CITY OF PORTLAND, MAINE
DEVELOPMENT REVIEW APPLICATION
PLANNING DEPARTMENT PROCESSING FORM

single family home w/garage

46 Garsoe Dr, Portland, Maine 04103

**CITY OF PORTLAND, MAINE
SITE PLAN REVIEW (ADDENDUM)
CONDITIONS OF APPROVAL**

SITE PLAN - LOT #28

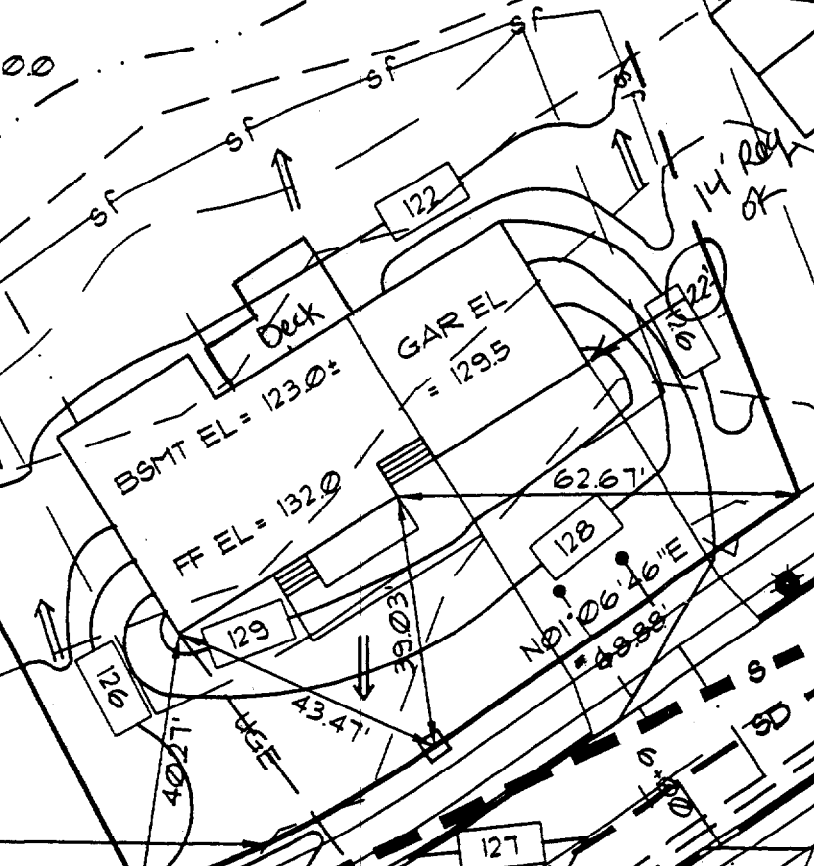
5. Show all utility connections: water, sanitary sewer, storm drain, electric, telephone, cable.
6. A sewer permit is required for your project. Please contact Carol Merritt at 874-8300, ext. 8828. The Wastewater and Drainage section of Public Works must be notified five (5) working days prior to sewer connection to schedule an inspector for your site.

9. X The building contractor shall check the subdivision recording plat for pre-determined first floor elevation and establish the first floor elevation (FFE) and sill elevation (SE) to be set above the finish street/curb elevation to allow for positive drainage away from entire footprint of building.

10. X The site contractor shall establish finish grades at the building foundation, bulkhead and basement windows to be in conformance with the first floor elevation (FFE) and sill elevation (SE) set by the building contractor to provide for positive drainage away from entire footprint of building.
